ADC ref: P/92/11/DOC

Butterlees Barn, Butterlees Farm, LAGNESS
Application P/145/08 – Discharge of Conditions

BUTTERLEES BARN - LHAGNESS
SITE PLAN AS PROPOSED
DWG: BUT/D-01F 1:200 @ A3 JUL 2008
MALCOLM SIMMONDS ARCHITECTS

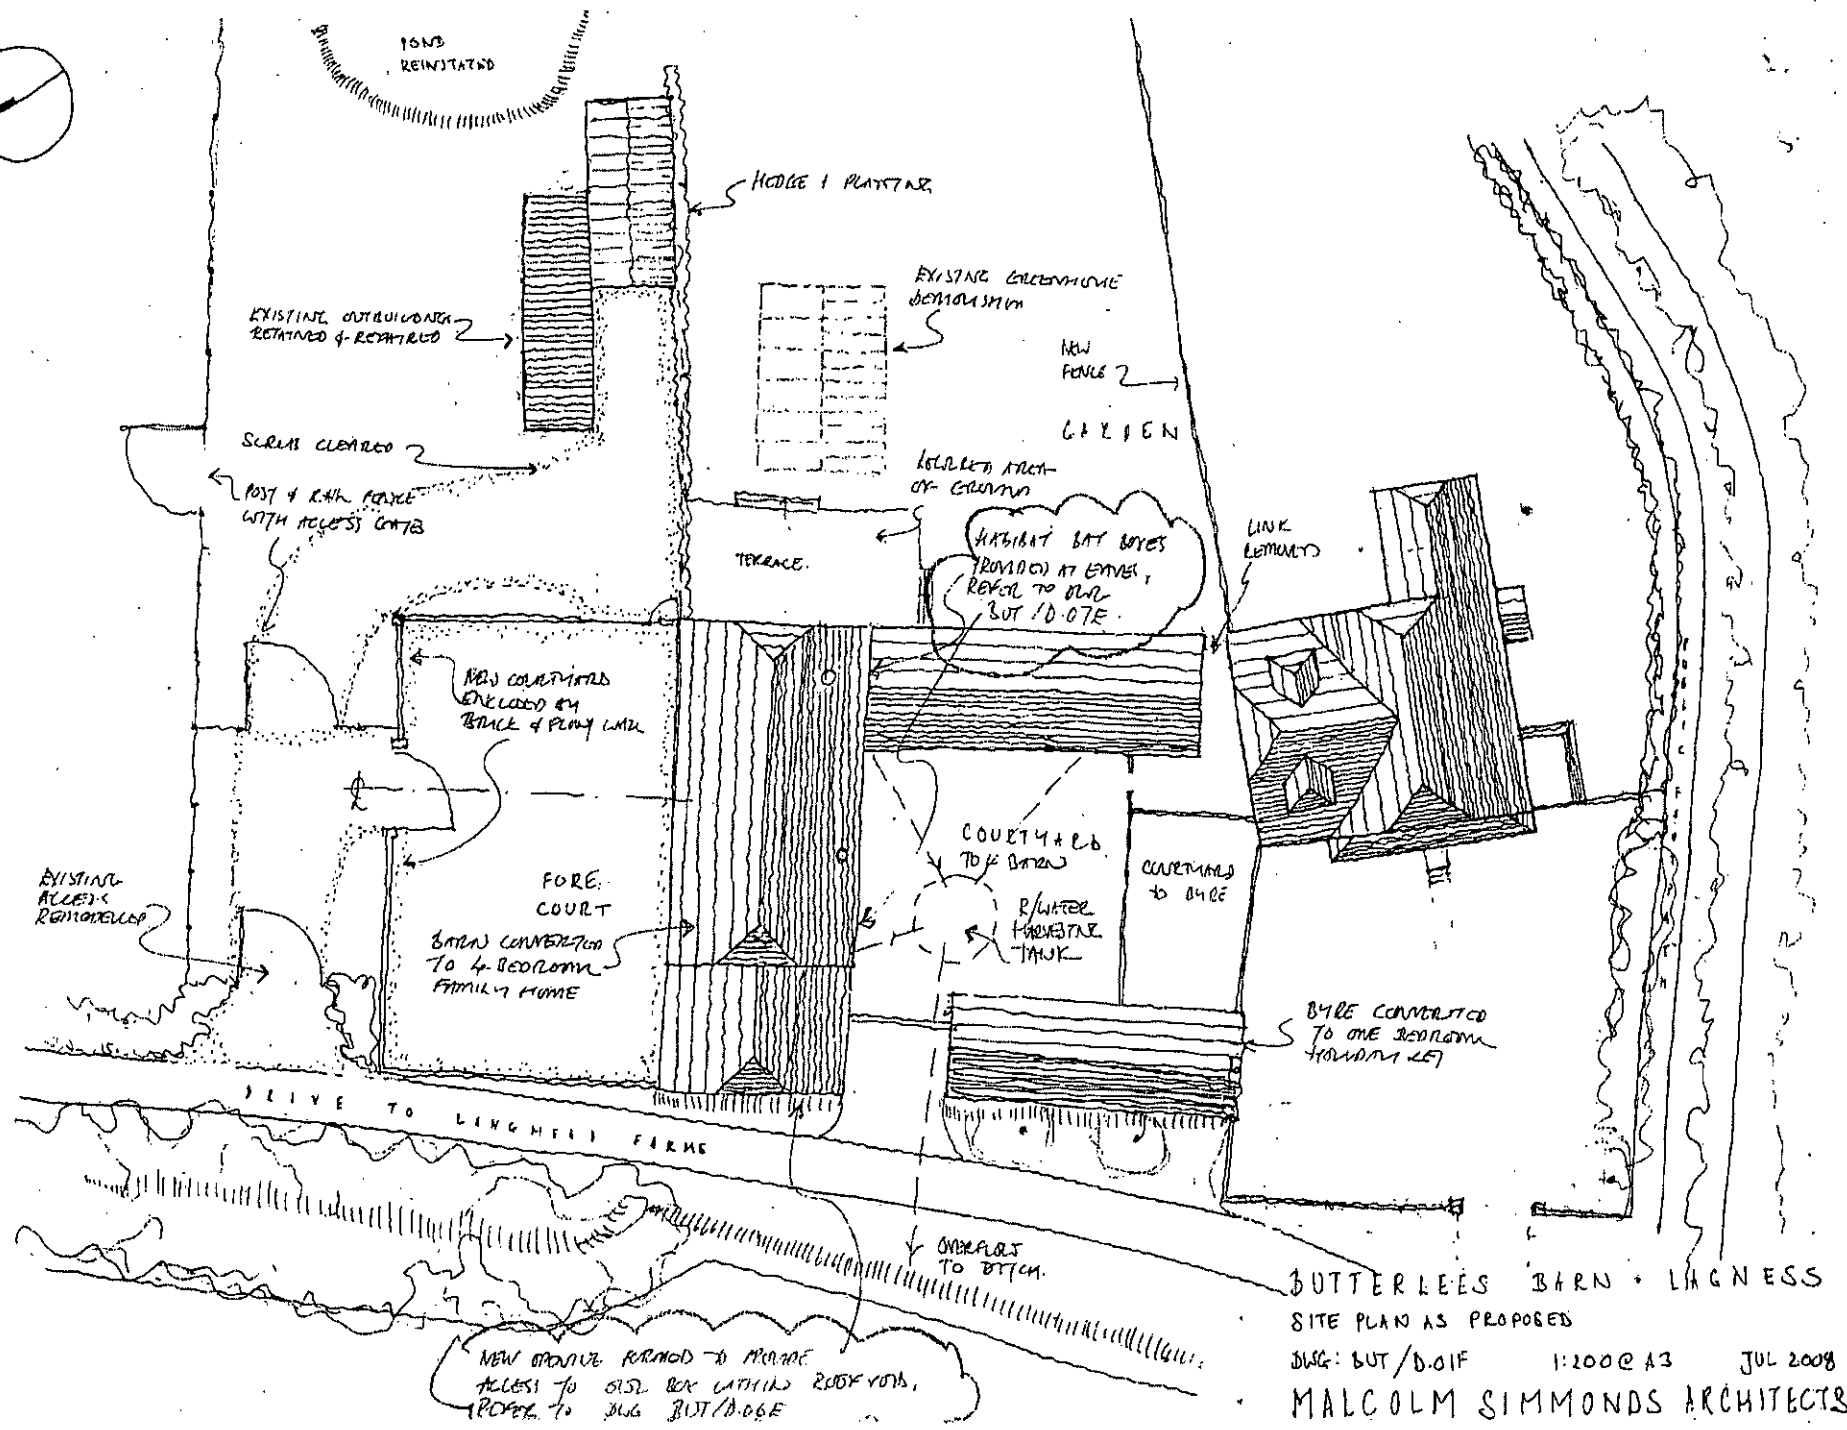
Thanks for the additional information. The locations for the bat boxes and the owl box seem appropriate. One would normally expect greater detail in terms of the design of the owl loft rather than simply a proposal to install an owl box in the roof void. Figs. 2 & 3 in attached Natural England guidance show how an owl loft can be created. If the applicant can commit to a similar design, I would then discharge the condition.

In summary, two bat boxes have been provided on the preferred south west elevation, these would be Habitat Bat Boxes with a custom brick facing to match the existing building. the owl box would be located on the south west corner of the building facing open fields and built into the building to provide the sort of shelter that Owl's prefer as well as be a discreet addition to the building.

BUTTERLEES BARN - LAGNESS
BARN & BYRE ELEVATIONS AS PROPOSED
LWG/BUT/D.OGE 1:100 C.A.B. JU 008
MALCOLM SIMMONDS ARCHITECTS

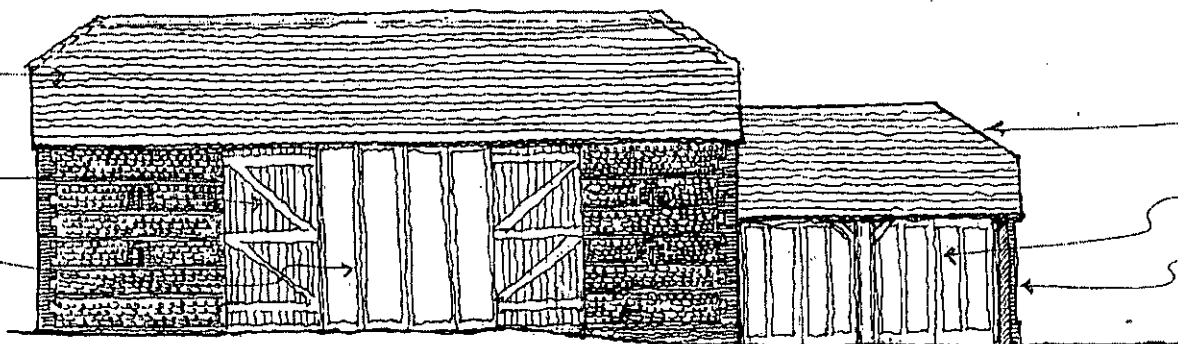
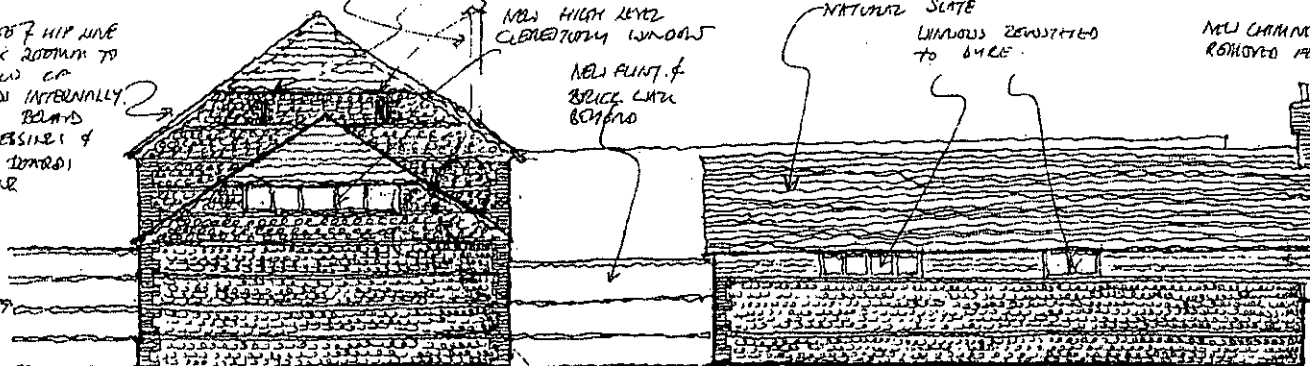
I note that Don, in his comments of 6th Feb 2012, recommended access and nesting provision (e.g. Schwegler No. 10 nestbox) should be provided for Swallows. Maybe this wasn't conditioned.

On the matter of swallow boxes, these were actually nesting on the house at the time and as they were not part of the survey requirement we didn't allow for any purpose made boxes on the barn but will incorporate these also and submit a revised drawing.
